City of Albuquerque  
Planning Department  
Inter-Office Memorandum

SUBJECT: Project # 1007922

On October 16, 2009, the Environmental Planning Commission approved Project #1007922, 09EPC-40048/40050, a Site Development Plan for Building Permit and a Zone Map Amendment from R-1 to SU-1 for Church and Related Facilities & A Day Care Center, for all or a portion of Lots 9A & 10A, Zapf-Van Addition #10, located on Montano Road NW between 4<sup>th</sup> Street NW and 9<sup>th</sup> Street NW containing approximately 2.36 acres.

SHEET NO. L101

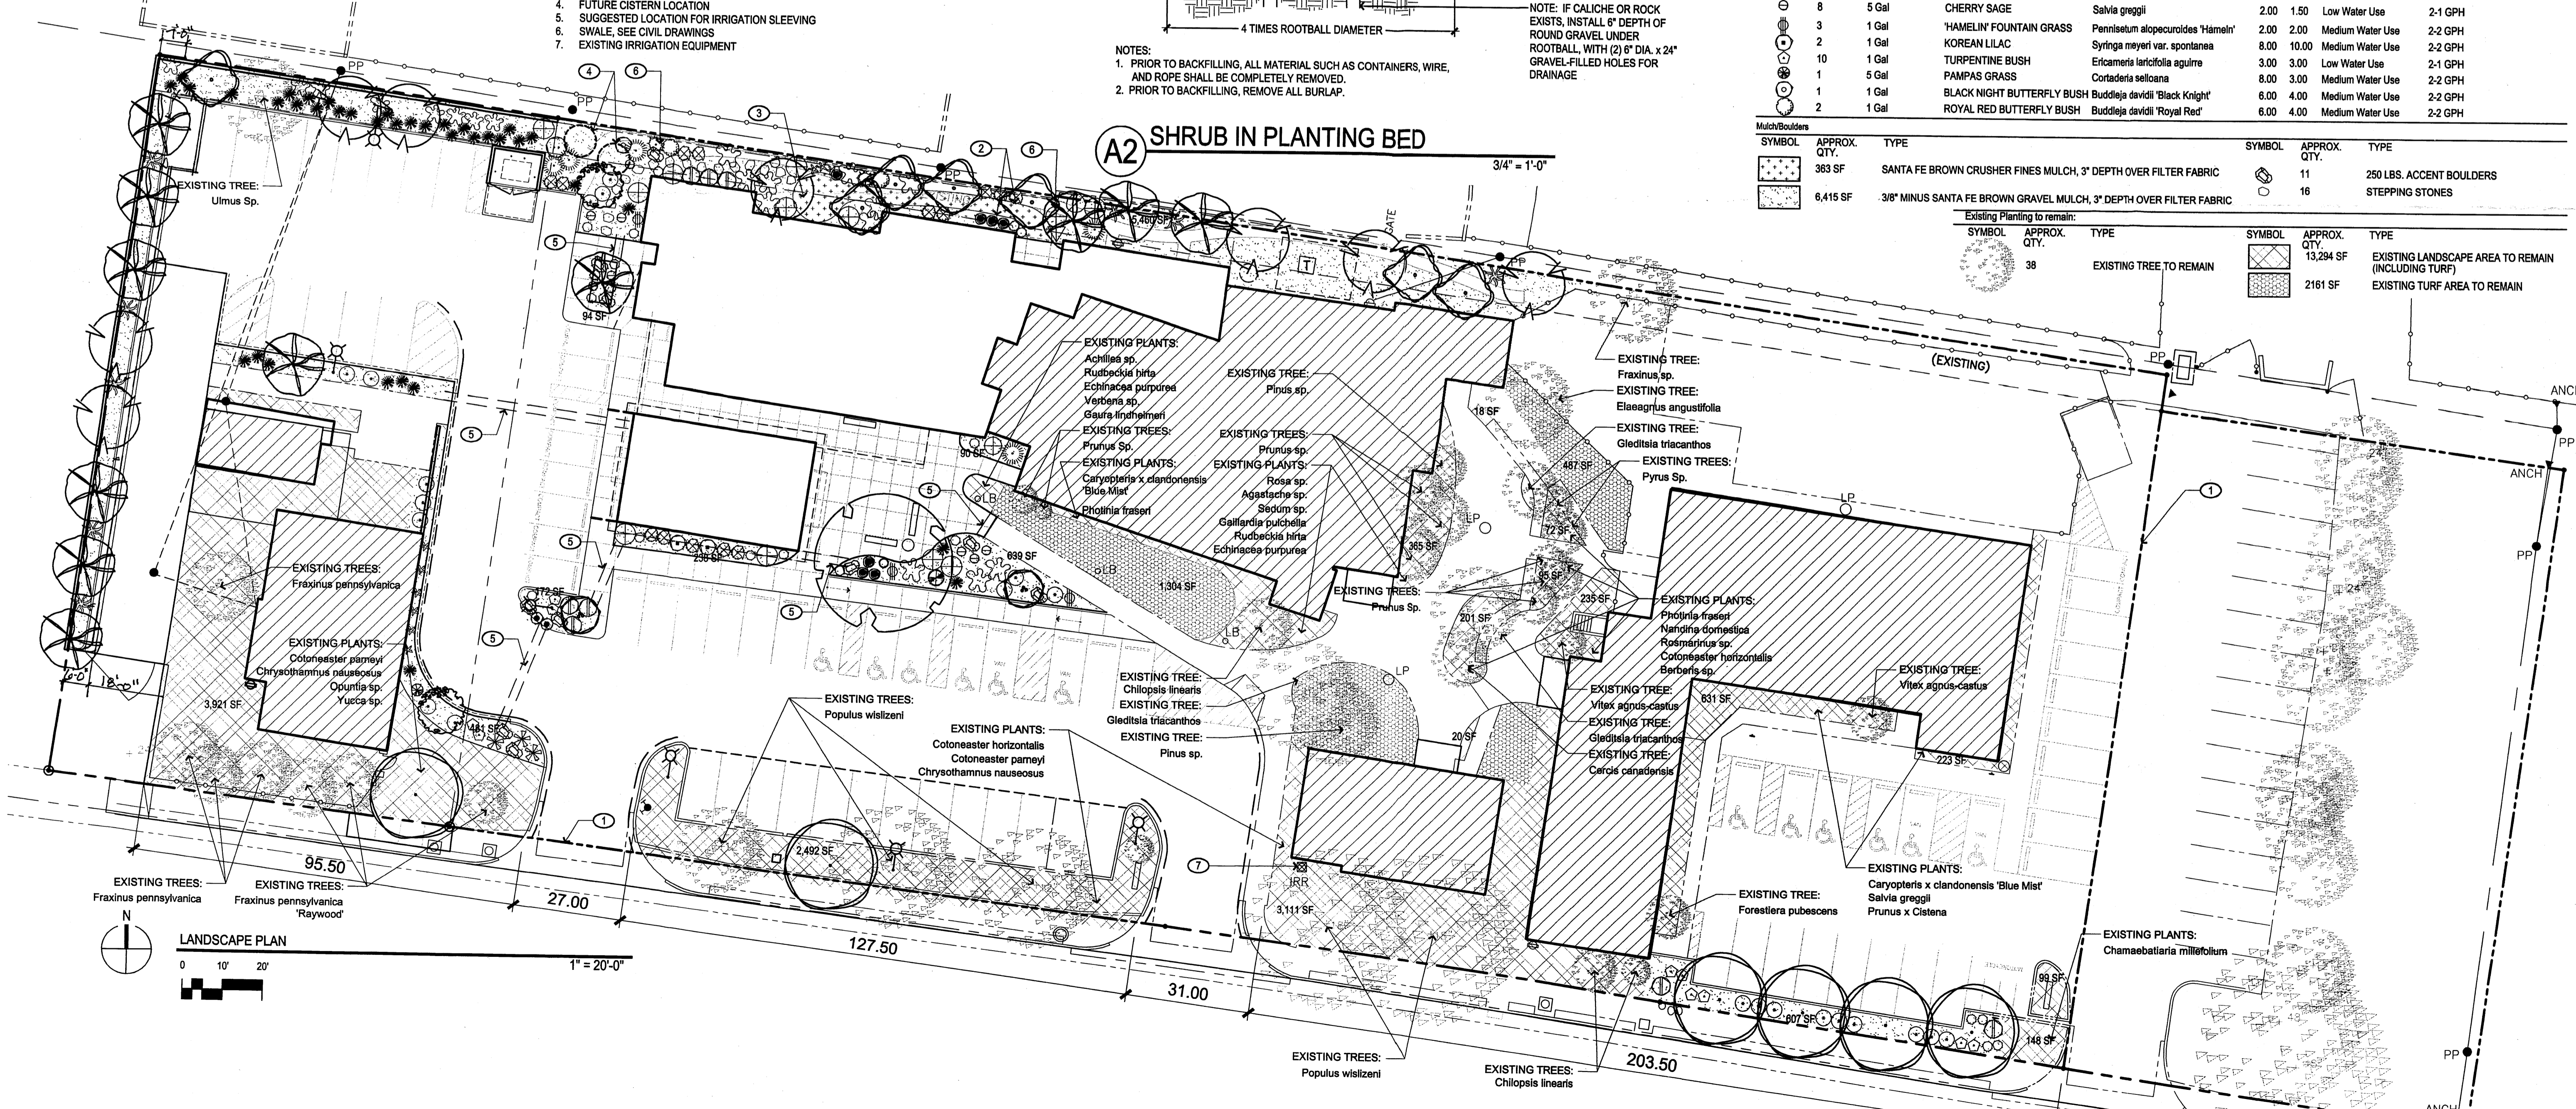
4a: All landscape buffers on Lot 10A that border a residential zone shall be a minimum of 10' wide, per Section 14-16-3-10 (E)(4)(a) of the Zoning Code.

4b: The buffer landscaping on the north and west sides of the site (Lots 9A & 10A) shall meet the special buffer landscaping/screening requirements (spacing of the trees shall be equal to 75 percent of the mature canopy diameter of the trees) in Section 14-16-3-10 (E)(4)(b) of the Zoning Code.

4c: The spacing of the trees along the northern portion of the site shall be adjusted as to not block solar access for the adjacent lot at 524 Gene. The required number of trees shall remain the same.

*Ginko tree (mature height of 50 feet) needs to be removed from this location and placed in another location as to not block solar access to the north.*

*This has not been done.*

*This has not been done.*

C2 DUMPSTER ENCLOSURE
SECTION 1/2" = 1'-0"

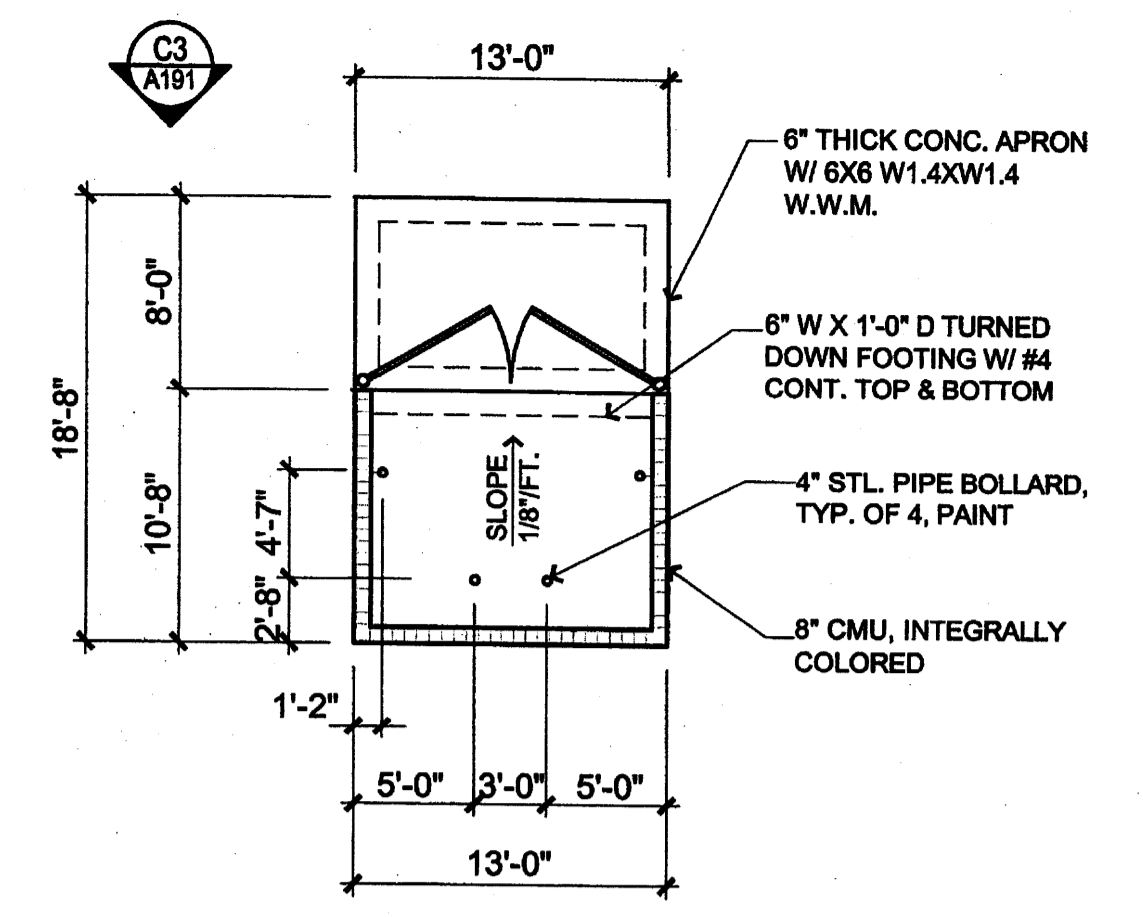
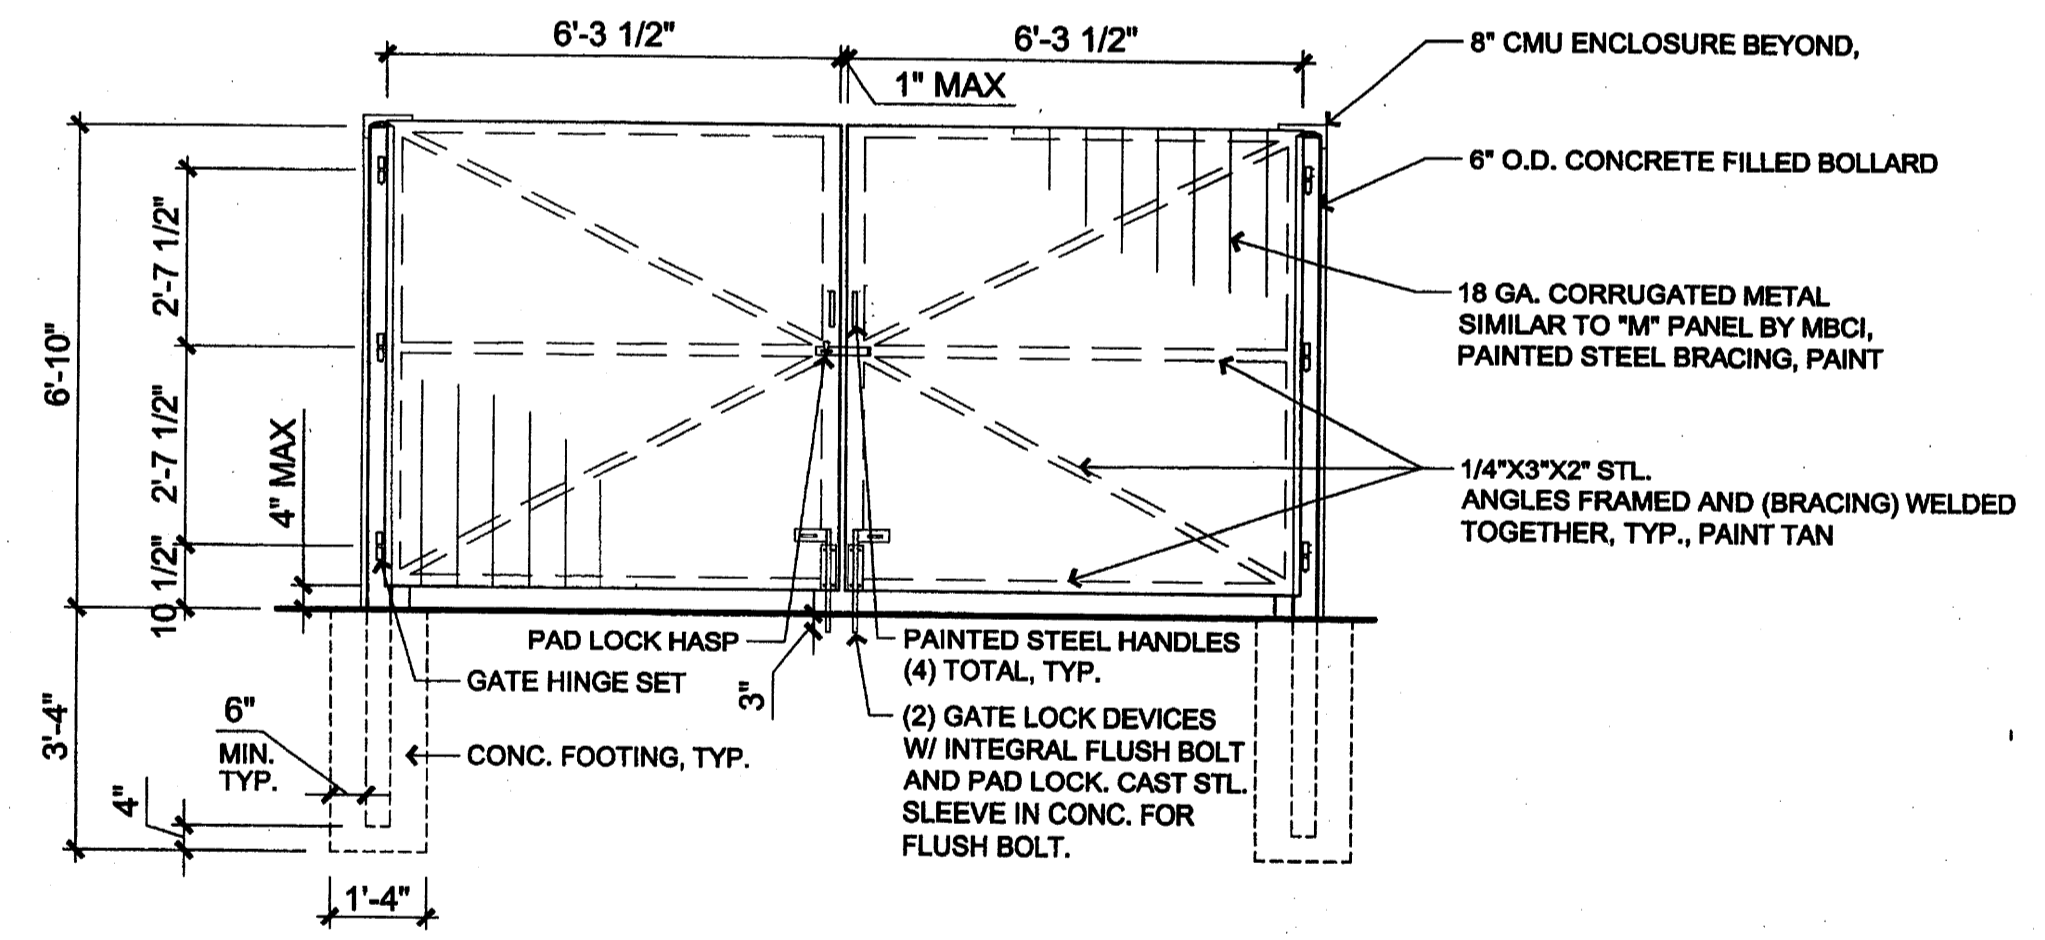
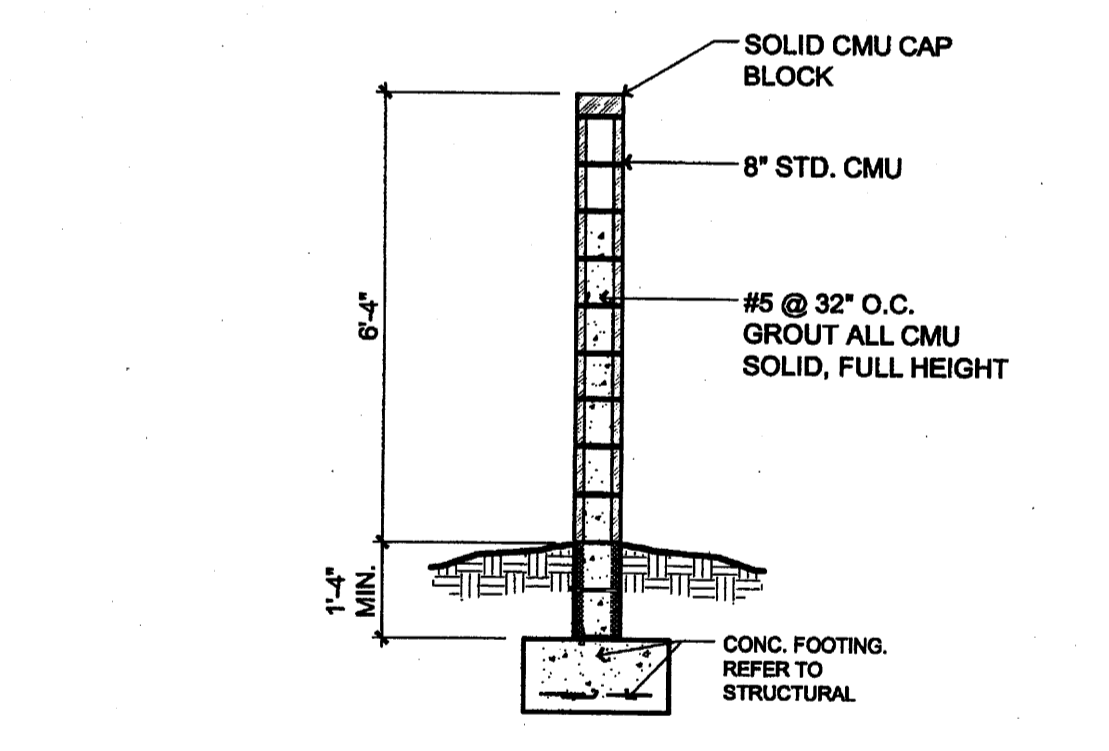
8: The site shall have double enclosures or 2 enclosures as requested by Solid Waste Management.

*This has not been done. Only a single enclosure is shown.*
